Address: 114 Foxroyd Lane Dewsbury WF12 0BD

Application number: 2025/65/90441/E	
What is the application for?:	Listed Building Consent for conversion of existing listed church to 2 dwellings,
Address of the site or building:	Church of the Holy Innocents, Vicarage Road, Dewsbury, WF12 9PD
Postcode:	BD19 5LX

FOR INFORMATION	
Project/Client:	Project No:
Church of Holy Innocents	22-111
Vicarage Road	Dwg No:
Dewsbury, WF12 9PD	A101
	Rev:
	A
Drawing:	Scale:
G.A. Information	A/S @A1
Site Plans	Drawn By:
As Existing & Proposed	RJ
	Date:
	Jun 23
	Checked By:
	Date:

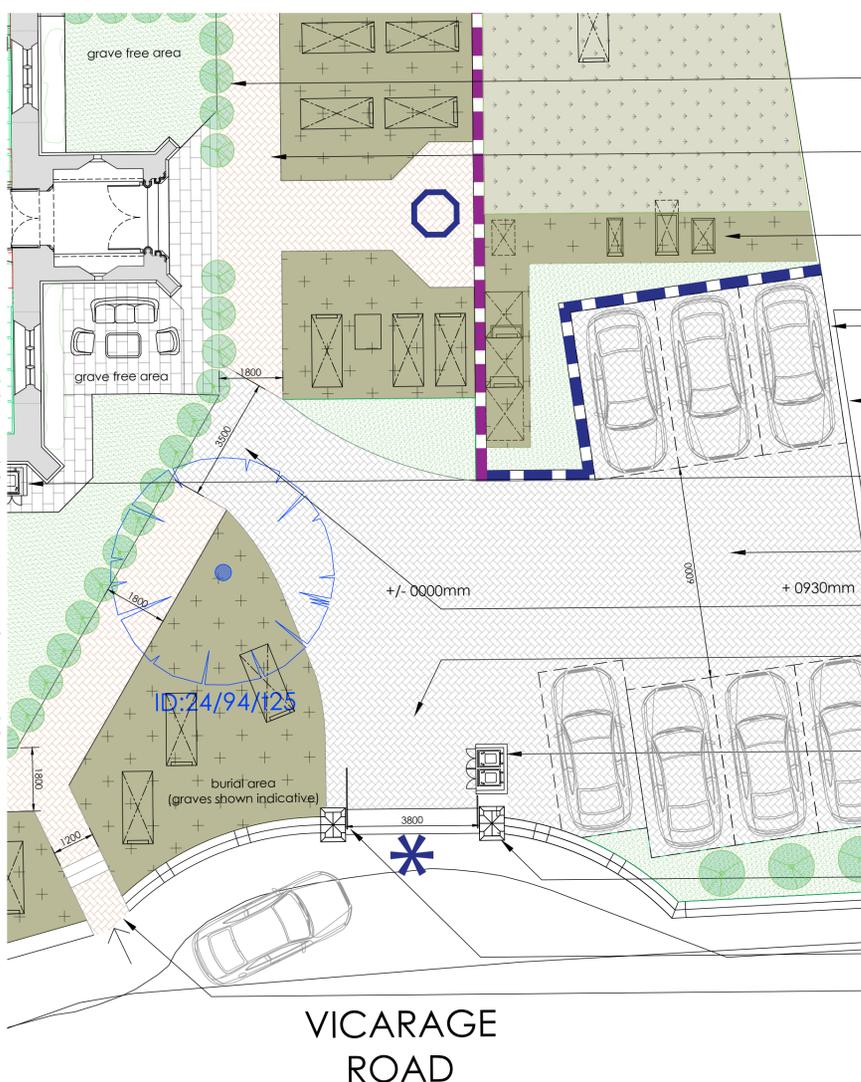
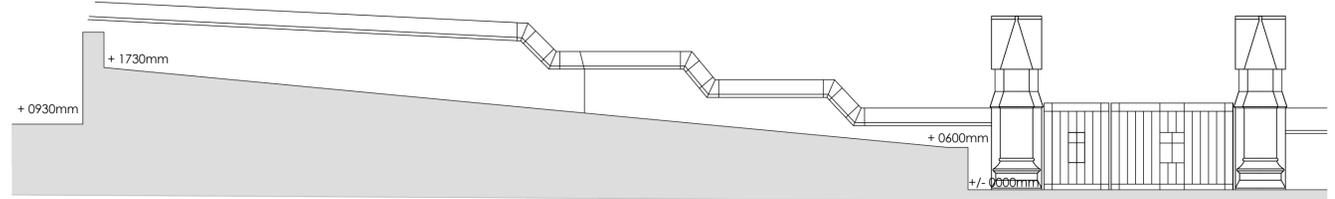
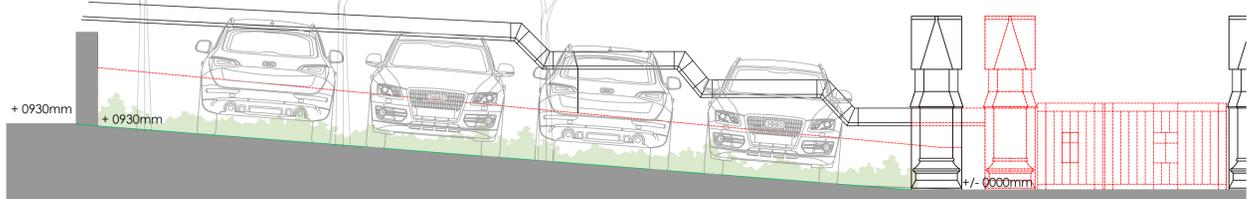
Type of comment: An objection	
Do you wish your comments to be published on the website anonymously?	No
<p>It is unclear from the drawings how access is going to be facilitated for me &amp; other people wishing to tend &amp; visit the graves of loved ones, at the moment we all park on the road &amp; walk in to the site which is all that I think needs to be maintained but it might not be appropriate if we have to walk past windows to the new residential conversion or have to visit graves with children playing noisily outside</p> <p>It would have been useful to have included some sort of screening between the properties &amp; the graveyard</p> <p>It cannot be right that we effectively have to walk across someone else's private space in order to visit our loved ones</p> <p>I am sure with some thought this could all be resolved easily</p>
